THE APPLICANT'S COMMENTS ON THE PROOF OF EVIDENCE BY THE CHIEF ENGINEER AT ANGLIAN WATER

FOR THE DEVELOPMENT CONSENT ORDER APPLICATION FOR THE ALTERATION AND CONSTRUCTION OF HAZARDOUS WASTE AND LOW LEVEL RADIOACTIVE WASTE FACILITIES AT THE EAST NORTHANTS RESOURCE MANAGEMENT FACILITY, STAMFORD ROAD, NORTHAMPTONSHIRE

PINS project reference: WS010005

The Applicant's response to the Proof of Evidence dated 13 April 2022 prepared by Mark Frogatt of Anglian Water (REP4-013)

Figure ESA5.1 Scale: 1:2,500@A2

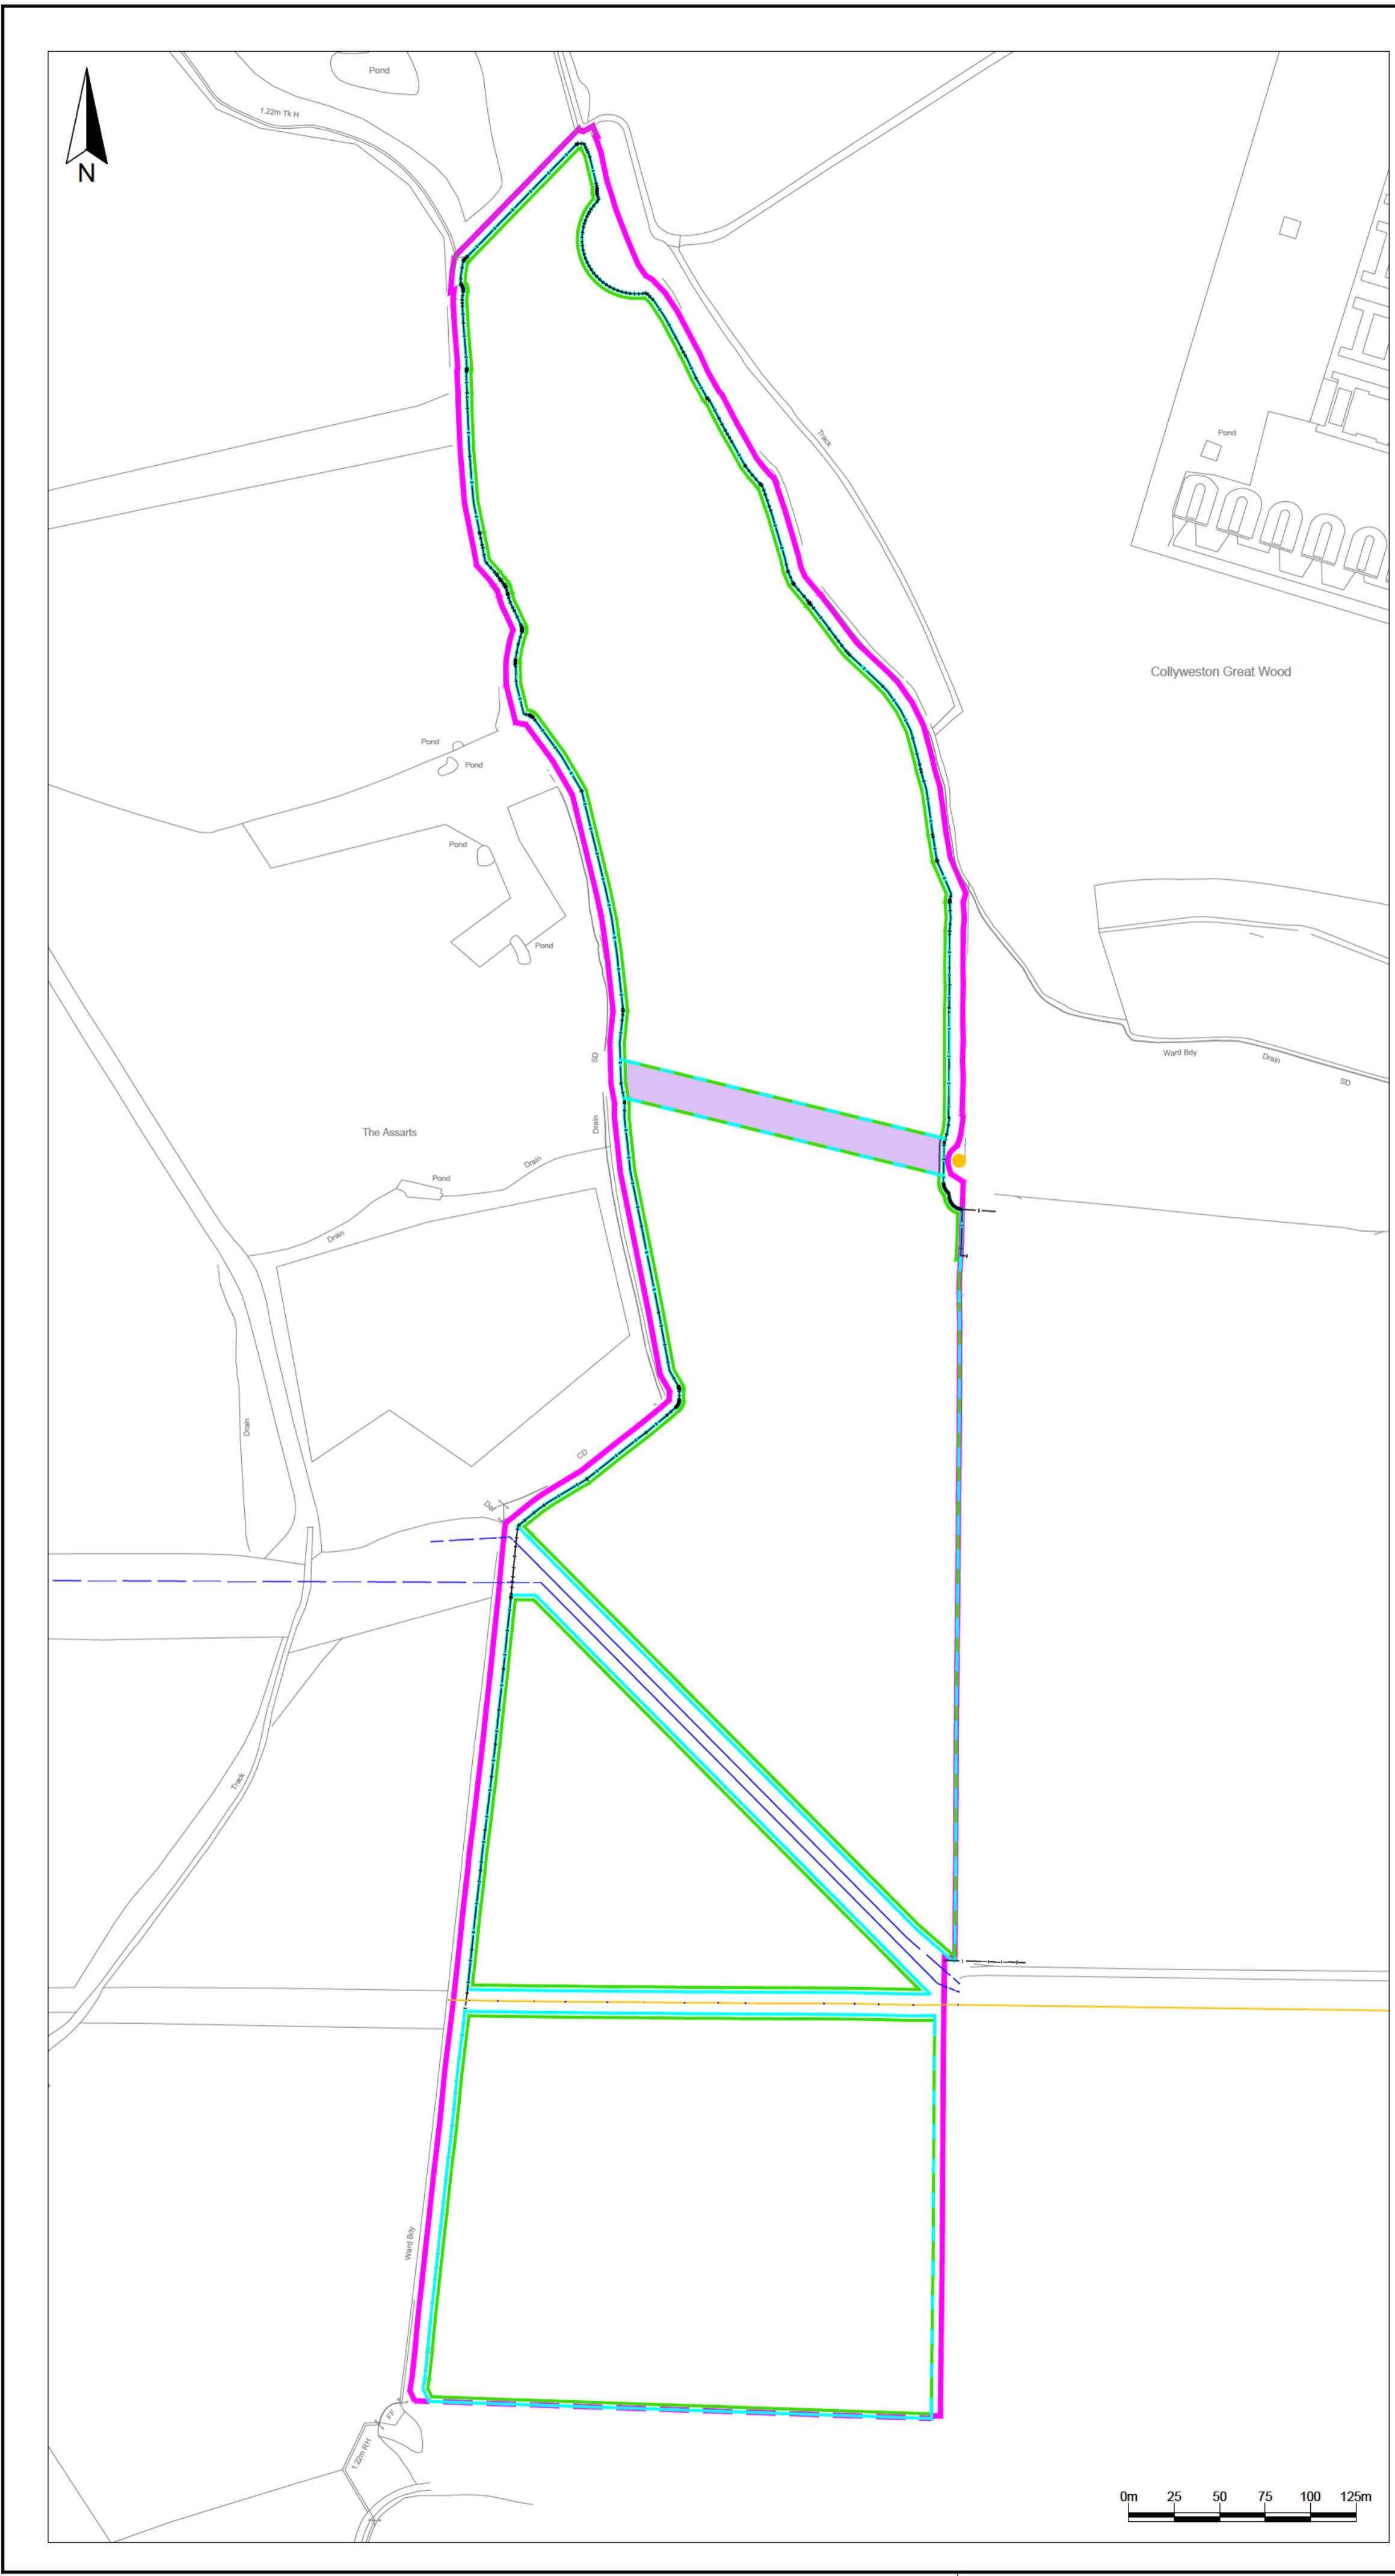
6. Anglian Water have two critical 800mm steel diameter transfer mains located within the area of the Proposed Development which function at a pressure of 8 bars ("the Mains"). The Mains convey wholesome water, for human consumption and supply a significant portion of Peterborough city area to be circa 80,000 customers. A plan showing the Mains in their current location can be found at page 1. This water supply (previously only one pipe) had been relocated from the black line on this plan to ultimately facility initial works on this site (phases 1-11).	The previous diversion took place as the landfill in Phases 1 to 11 (the current landfill site) was designed to fill the area in which the water pipe was formerly located as the site could not be designed in a practical way to stand away from the pipe. This diversion took place before Augean took over the operation of the facility. The Applicant notes that the diverted pipeline and the new, second pipeline which was added (to increase the level of resilience and increase capacity) are located approximately 15m to 20m to the south of the excavation boundary of the current site which is designed to the same principles and filled with the same wastes as proposed for the western extension area. A gas pipeline runs parallel to, and approximately 4m to the south of the southern water pipeline.

<p>8. In view of this concern, I attended the first DCO hearing on 29 March 2022 and the site meeting shortly thereafter 5 April 2022. On both occasions I voiced my concerns (set out further below) in relation to the risk of leaving the Mains in situ.</p>	<p>We have been in discussion with AW since 2020, including with the individual identified Growth Liaison Manager for this region (John Young) identified in the “Anglian Water’s Cross Sector Infrastructure Access Statement (March 2019) [Document reference 12.2.8.1].</p> <p>The easements were discussed with AW on 15 January 2021. At AW’s request a schematic cross section was prepared to show the standoffs from the excavation and the location of the rerouted electric cable, so that they could be shown to others at AW. This was issued on 3 February 2021 and is provided at Appendix ES5.1 [APP-083]. Augean and MJCA were then copied in on an email from within AW which concluded with the comment between Ben Haycock and John Young (both of AW) saying: <i>“Hi John, From the drawing all looks to be fine. Is the electric cable high or low voltage? Thanks Ben”</i>. AW did not raise any further comments on the proposed stand offs at this stage.</p> <p>No concerns whatsoever regarding the previously agreed standoff distance were raised prior to a meeting on 1 March 2022.</p>

13. Notwithstanding reiterating my concerns I do not believe that Augean have changed their view in relation to moving the Mains.	<p>Augean were led to believe as a result of all the consultation responses and discussions with AW that provided the recommended standoff (7m either side of the water pipes) would be implemented, Anglian Water were satisfied that there were no unacceptable risks. Accordingly the Environmental Impact Assessment was scoped and the site was designed on this basis. The potential for diversion of the pipes was not required by Anglian Water at any point.</p> <p>The Applicant believes that the appropriate response to the concerns now raised by AW is by robust risk assessment based on which any potential changes to design or extent of stand offs can be considered.</p>
Grounds of Objection	
<p>14. It is Augean's proposal to leave the Mains in situ and allow a buffer zone around the same. Initially a buffer zone of 7 meters either side of the Mains was proposed which would include within it a high voltage transmission cable within 3 meters of the Mains. Anglian Water's initial concerns were that 7 meters would not be sufficient. It was then mooted that 20 meters maybe more appropriate however on closer consideration a buffer zone of any distance in these particular circumstances would be wholly unsuitable. Primarily this is because if the Mains were to fail (i.e breach) the consequences would be extremely severe damaging both the Mains themselves (likely beyond repair) as well as the Proposed Development.</p>	<p>The statement is not consistent with observation on the ground, For example there is a buffer zone of 15m to 20m in place between the existing site and the diverted water pipes which were installed by AW in around 2000 and therefore this would have been considered acceptable at the time. These water pipes also run close to (within 4m of) the high pressure gas main the proximity to which also must have been assessed by AW as acceptable before the pipe was diverted and an additional pipe was installed. From discussion with AW on 9 May 2022 it is understood that a 20m standoff would be acceptable from an operational access perspective and, we are informed by AW, is consistent with the standoff requirement for the current Strategic Pipeline Alliance Pipeline currently being developed in the region. The applicant is considering the comparative appropriateness of this proposal within the risk assessment process.</p> <p>The Applicant accepts that there is the potential for Mains to suffer leaks and possibly catastrophic failure, as for all water pipes, and that there will be a need for access to be available so that they can be repaired on a regular basis. This is what the standoff distance is intended to allow for. The Applicant is working proactively to elucidate as precisely as possible the specific circumstances and the concerns of AW in order to carry out and present the appropriate risk assessments now requested by AW and ultimately determine the appropriate standoff.</p> <p>The reference to damage of the mains 'beyond repair' is not understood. Whether pipes leak or burst they are capable of repair, it is the extent of repair needed which will vary but we are not clear how the circumstances are different to any other development next to a</p>

burst in one or both pipes.	assessment of risk to or of the pipelines based on the principle that the recommended and previously agreed standoff (7m either side) would be implemented.
